20 July 2018

Re: Little Deerswood, Gorse Avenue East Preston BN16 1SF

I refer to this planning application for the demolition and erection of 1 No. dwelling with swimming pool. I represent Kingston Gorse Estate (Sussex) Ltd who own the freehold of the verge outside the property.

Site Plan as proposed

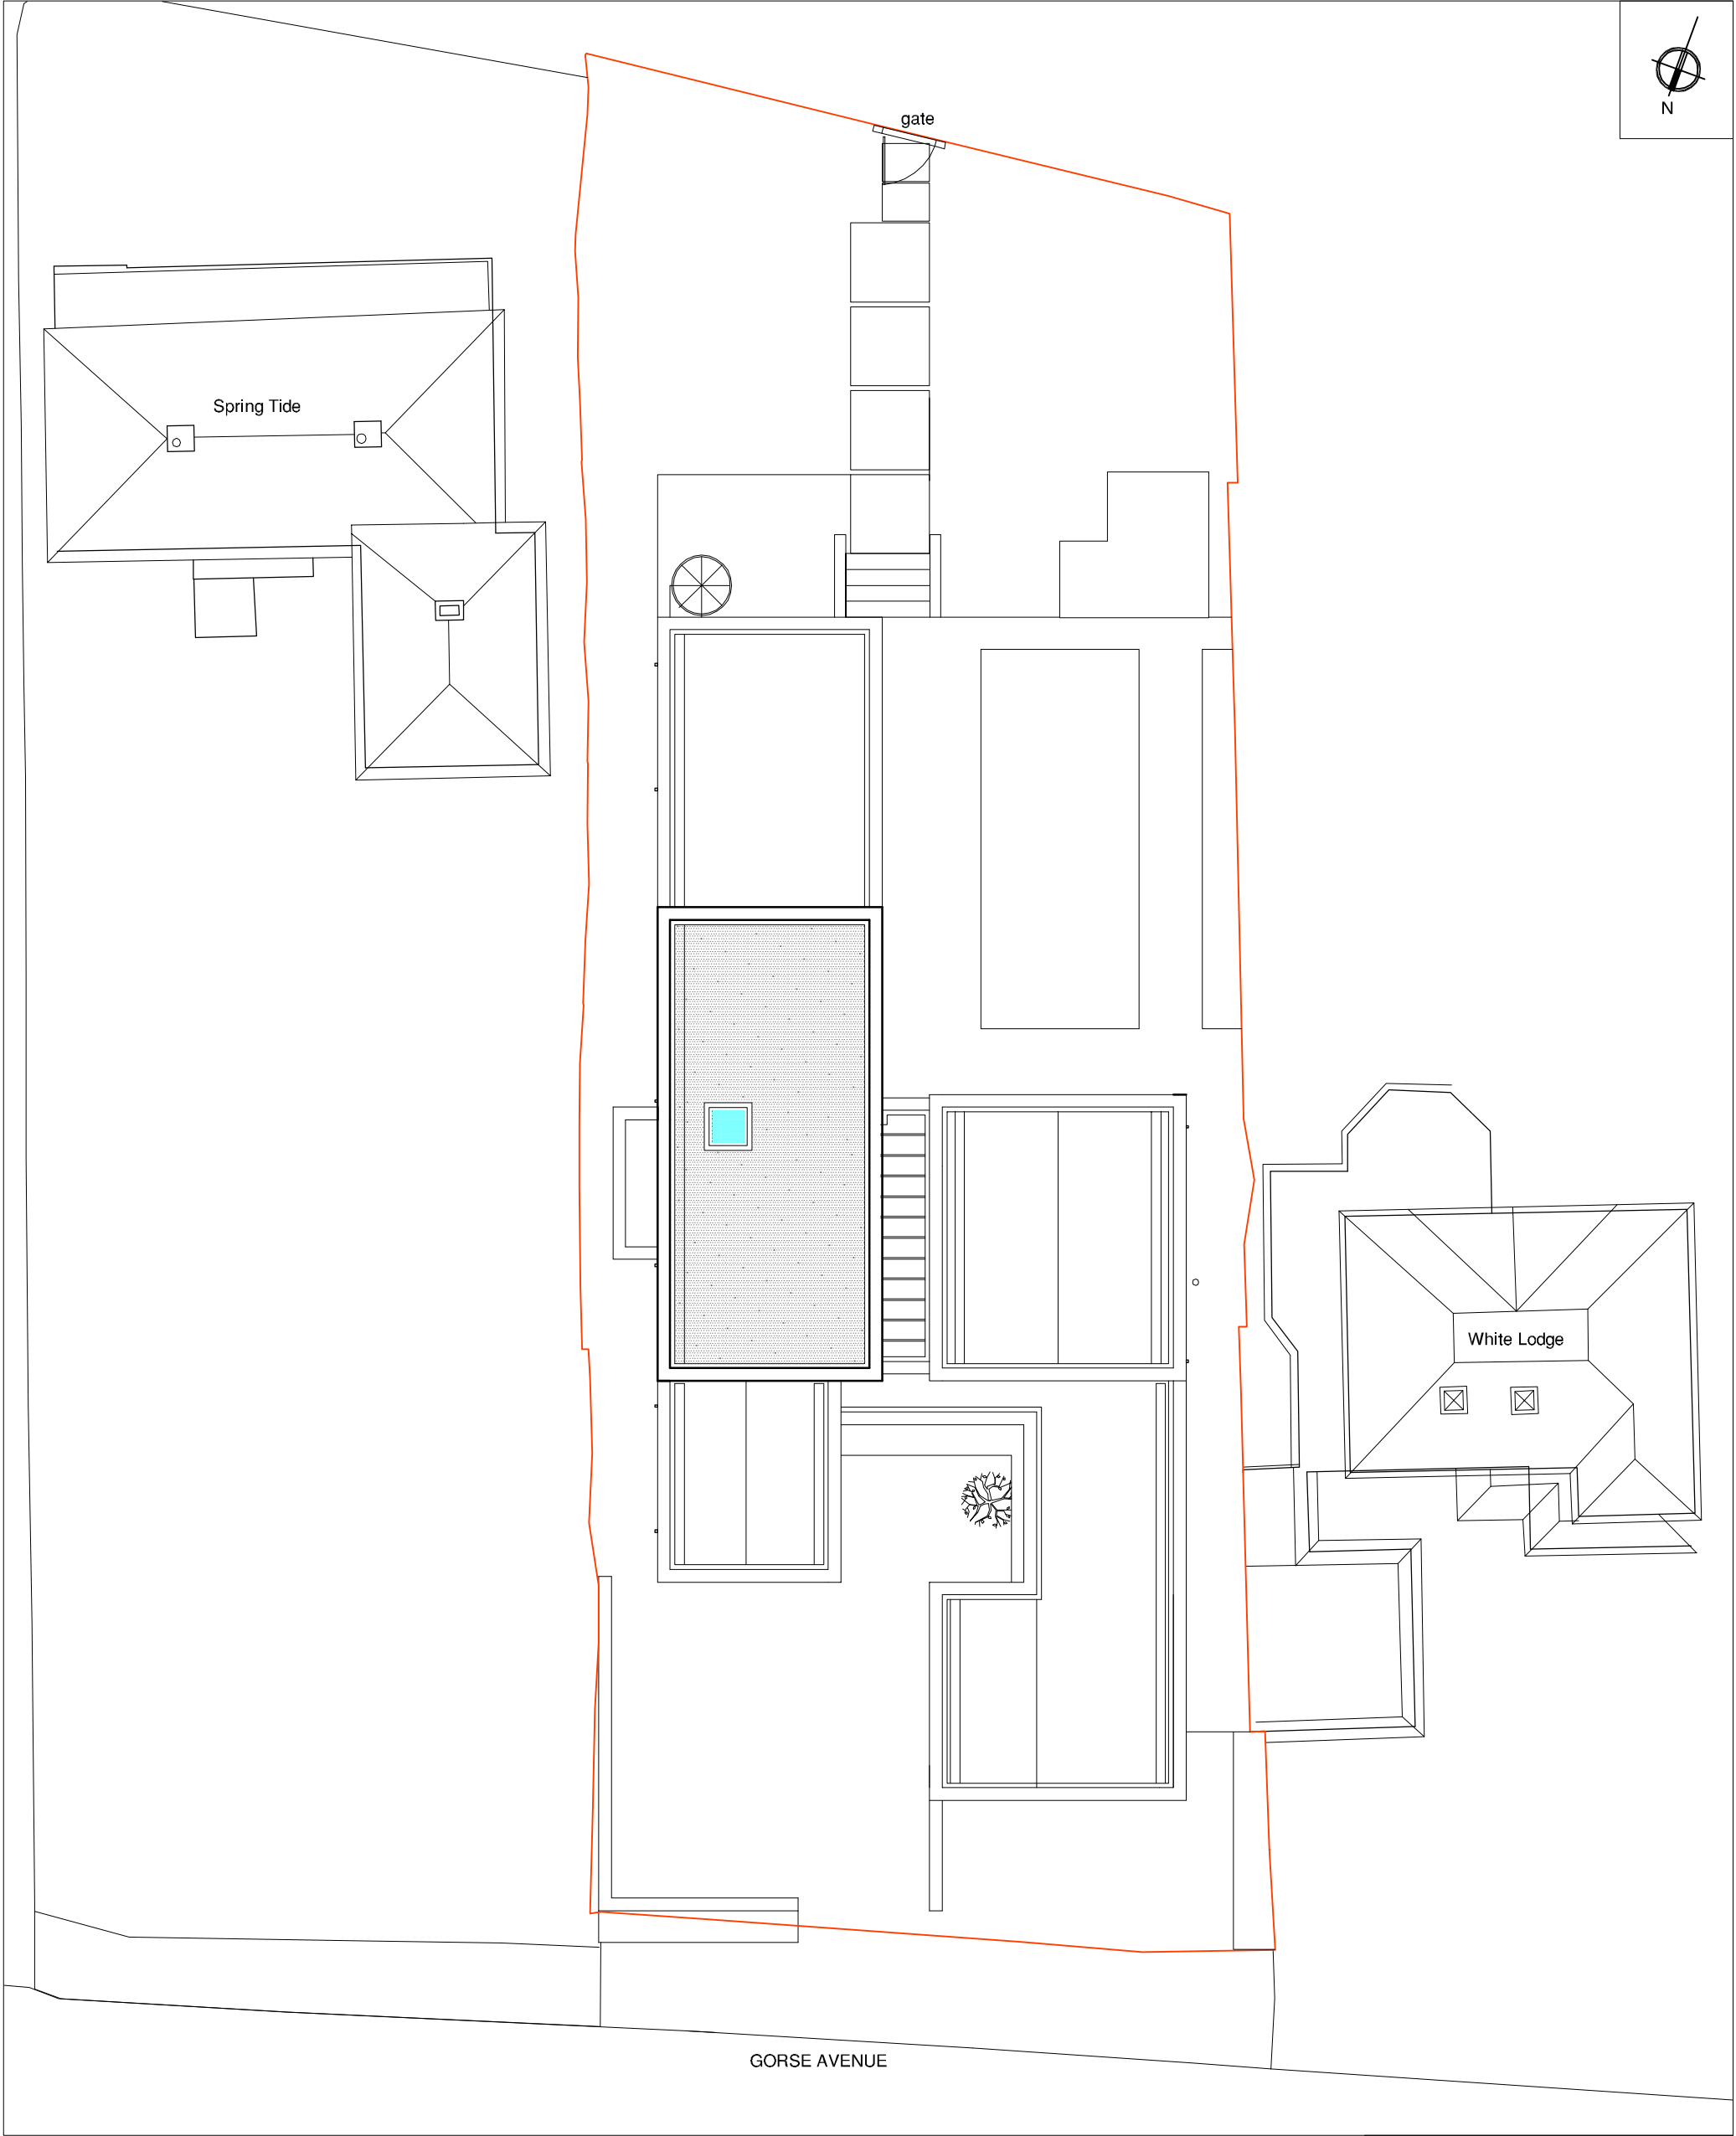
The drawings submitted with the application indicate a new pedestrian access and a significantly wider and increased vehicular access, both of which impact on the grass verge.

As the verge is owned by the Estate I would suggest that the applicant should have completed certificate B rather than A, and also issued Notice 1 to Kingston Gorse Estate (Sussex) Ltd. Please let me have your comments.
